PROJECT: Frasers Block 11 - Central Park

Apartment Design Quality Letter

We have reviewed the Department of Planning and Environment's query with respect to the area of apartments E1308 and E1309 and offer the following.

TITLE  
PLANS  
Level 13

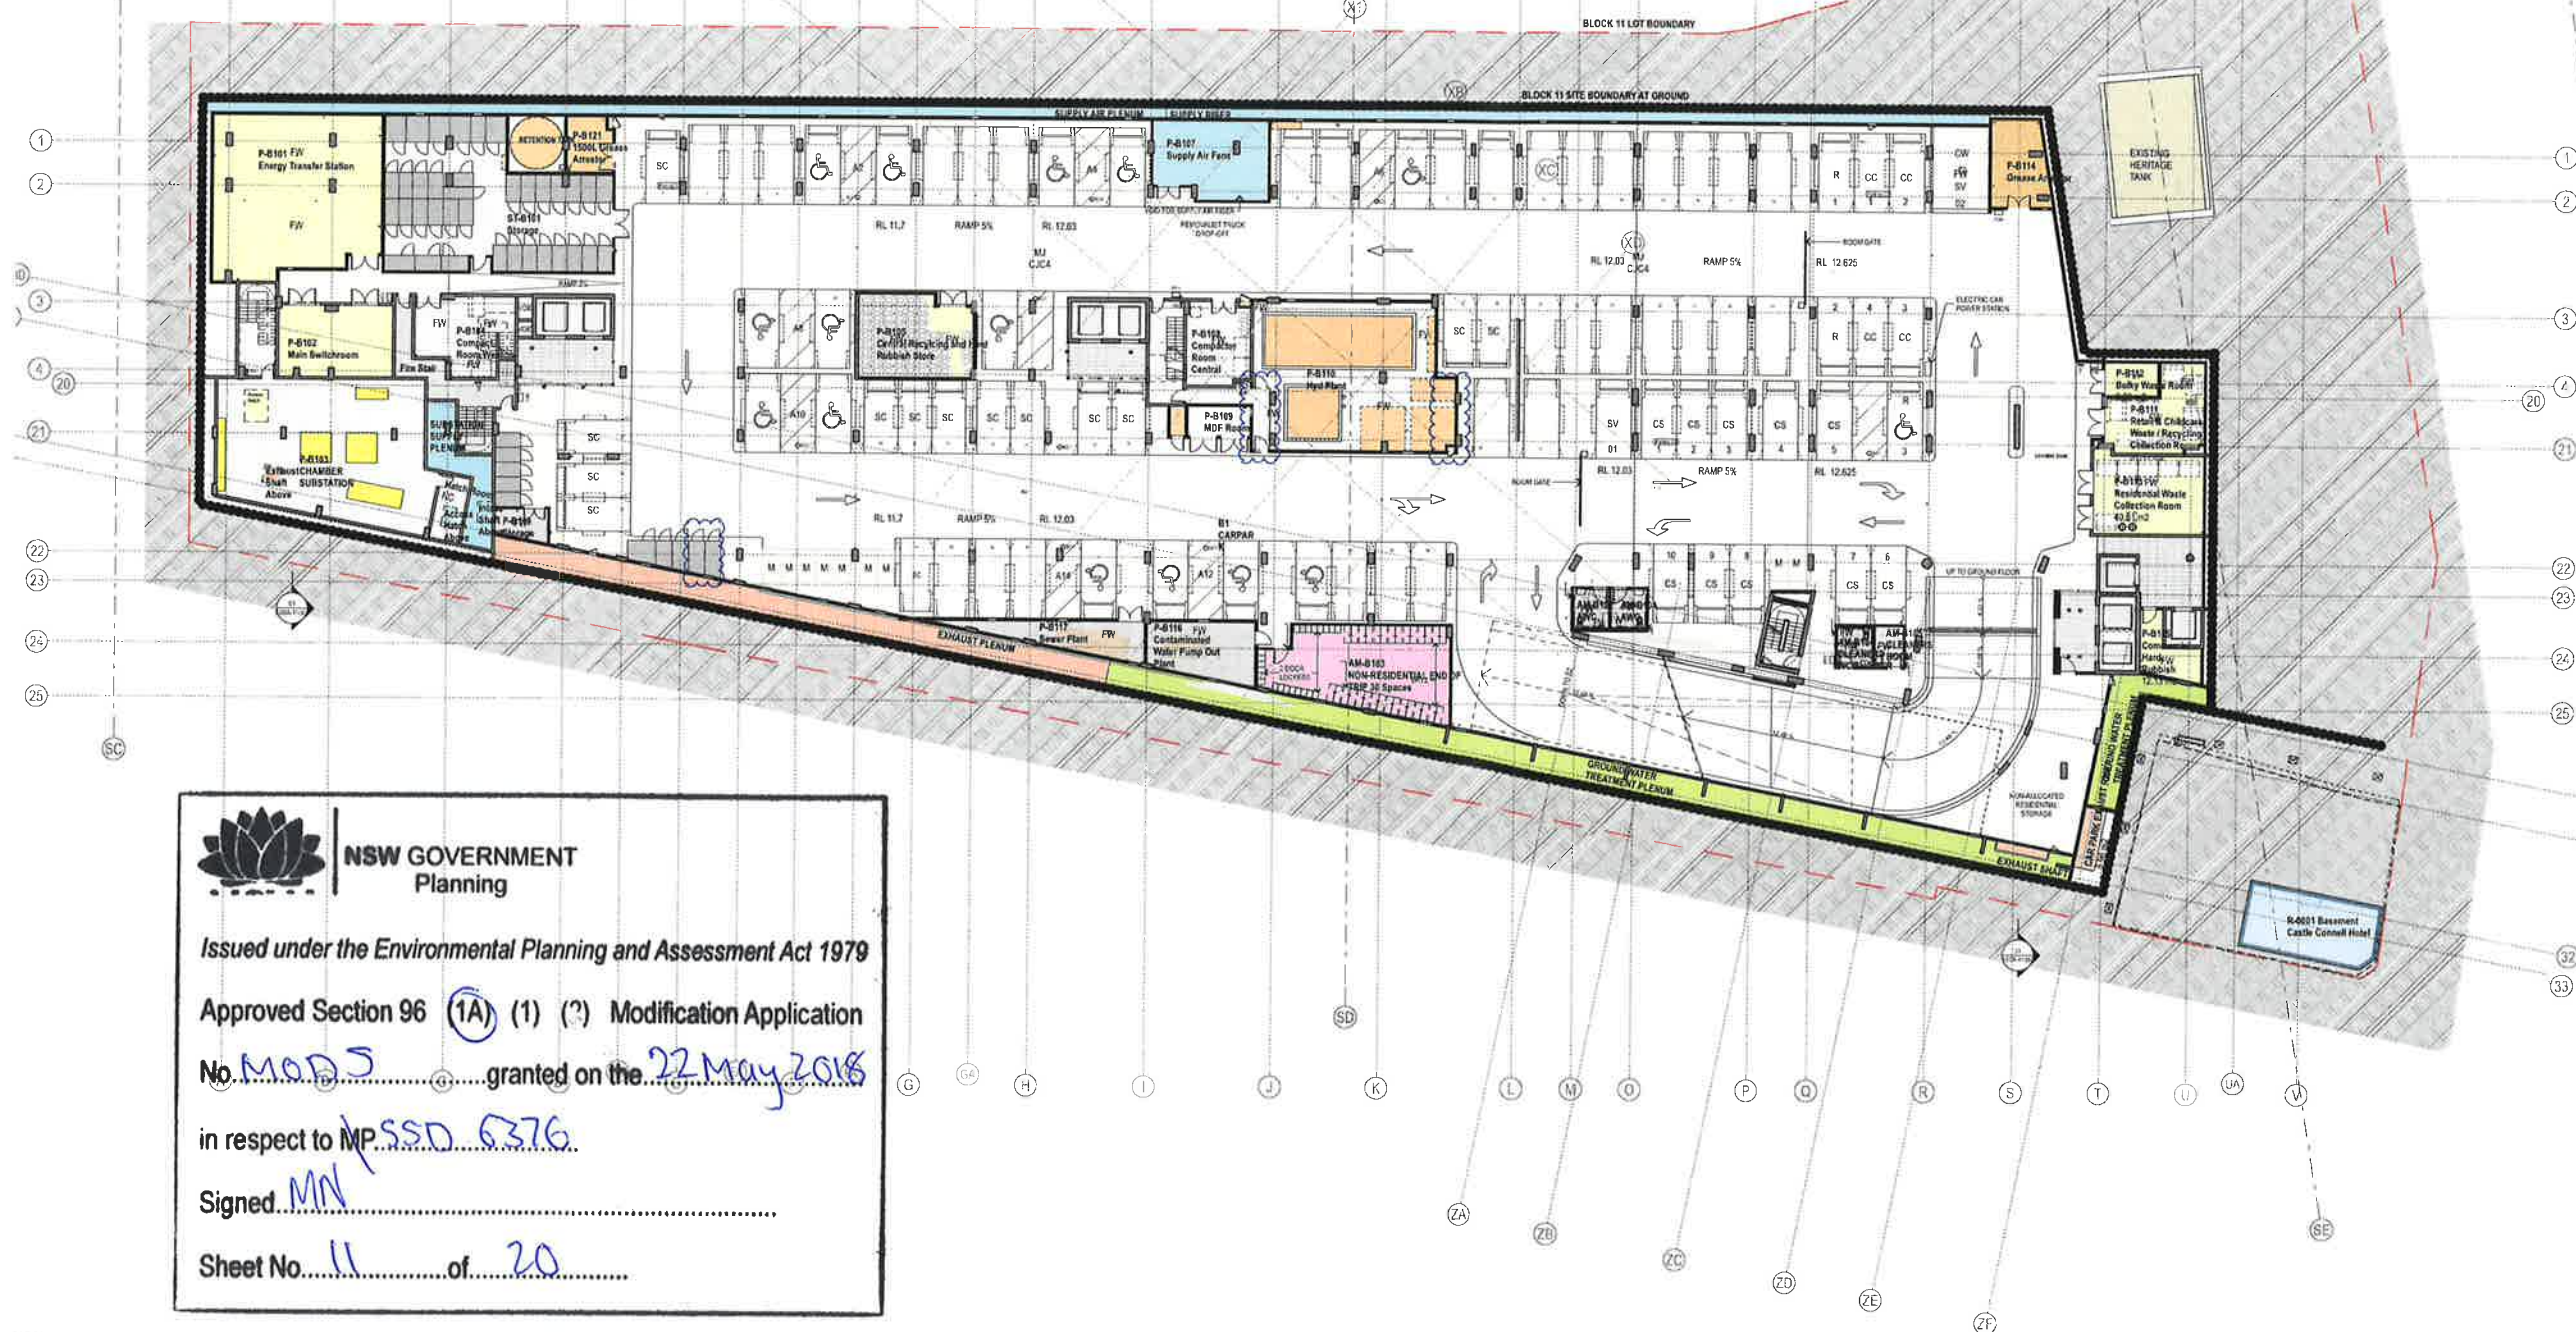
We note that the internal apartment areas of E1308 (54.5sqm) and E1309 (50.1sqm) meet the ADG and RFDC minimum requirement for 1 bedroom internal area requirements. We note that E1308 (8.7sqm) satisfies the ADG and RFDC private open space requirements of 8sqm for 1 bed apartments. However, E1309 (6.5sqm) due to services constraints, has a minor non-conformance in its private open space.

The bedroom, bathroom, storage and kitchen areas meet or exceed the relevant area guidelines and we believe that due to the high quality planning, amenity, natural light and panoramic suburban views that this minor departure from the standard, whilst unfortunate is an acceptable outcome.

The kitchen, dining, living & balcony spaces have been arranged into an open plan column free area to optimise efficiency of space and orientate occupants to the panoramic suburban views.
